Reference: FP/7/22/T

Location: The Green (bordered by Copeland Rd, Minton Rd and the Ridgeway), Felpham, PO22 8EF

Proposal: 1no. willow tree (1) - remove 6m on N/E side to leave 2m and crown lift over road up to 2.5m. 1no. pine tree (2) - remove lowest limb on S/E. 1no. holm oak (3) - Crown lift over road up to 2.5m and remove limb going into pine tree. 1no. poplar tree (4) - re pollard to previous points. 1no. pine tree (5) - Crown lift up to 2.5m on South side

REF 1

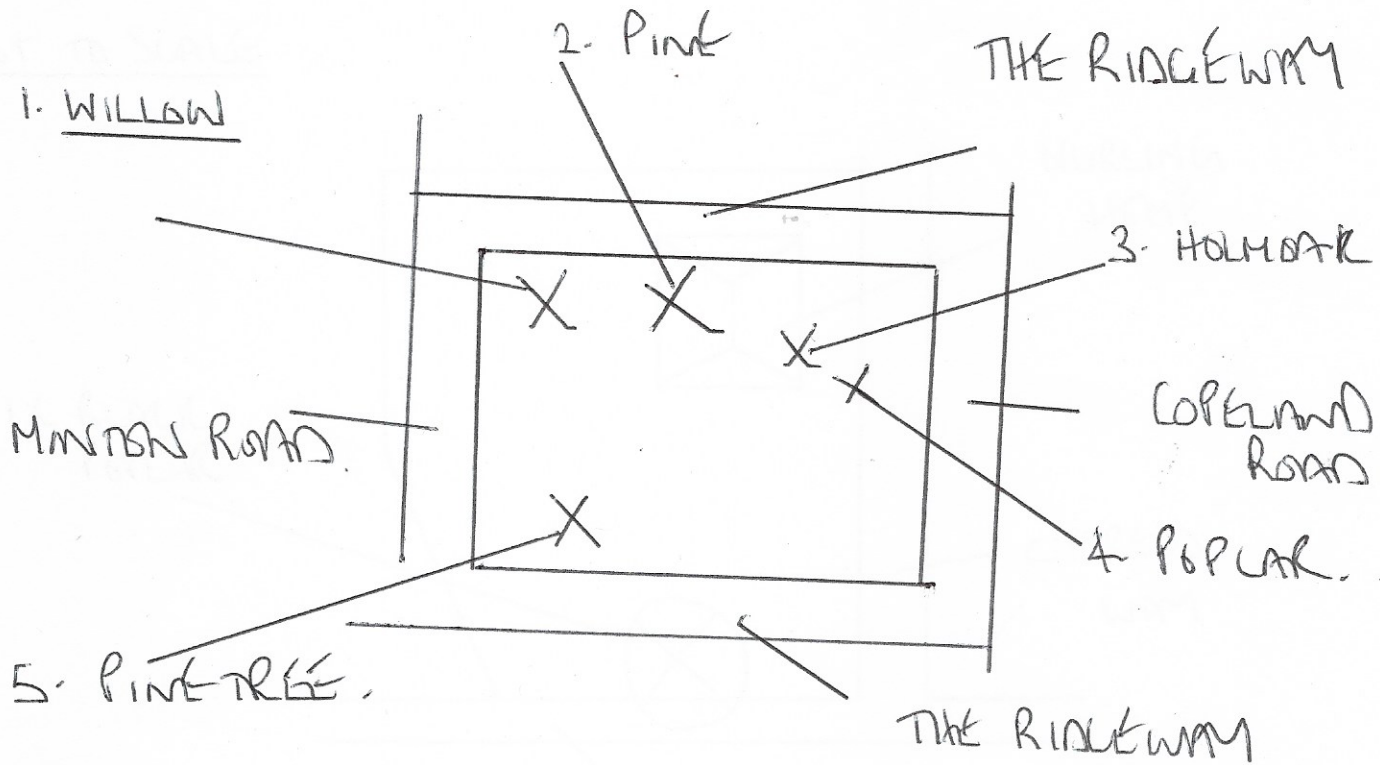
T2 Monterey pine / *Pinus radiata* Height: 10-15m Radial spread: 5-10m Age class: Mature

T5 Monterey pine / *Pinus radiata* Height: 10-15m Radial spread: 5-10m Age class: Mature

- The Green is affected by area Tree Preservation Order, Bognor No. 5 (A9). It protects whatever species were established at the time the Order was made (1963). My judgement is that only items T2 and T5 would be protected by that Order. The remaining trees listed in the proposal are not suitable candidates for a new Order so we need not consider them further.
- Outwardly both trees appear to be in a fine physiological state. They are visually impressive with heavy low branches contributing greatly to their character.
- They appear slightly stunted, a probable consequence of growing at such an exposed coastal location, to which they have adapted well. They can be clearly seen from numerous residential dwellings and to highway users. As such, they have high amenity value.
- Crown clearance from carriageways appear adequate at this time.

- There is no obvious arboricultural justification for the work proposed (T2 & T5). Those trees are a significant feature in the local landscape and appear to be in adequately sound and healthy condition. The tree surgery proposed in the application would result in excessive reduction of their landscape impact and undue detriment to the visual amenities of the locality.
- T1, T3 & T4 are not the subject of any Order or within Conservation Area, so consent from the local planning authority is not required for the work proposed.

- I recommend **REFUSAL** for this application (T2 & T5).
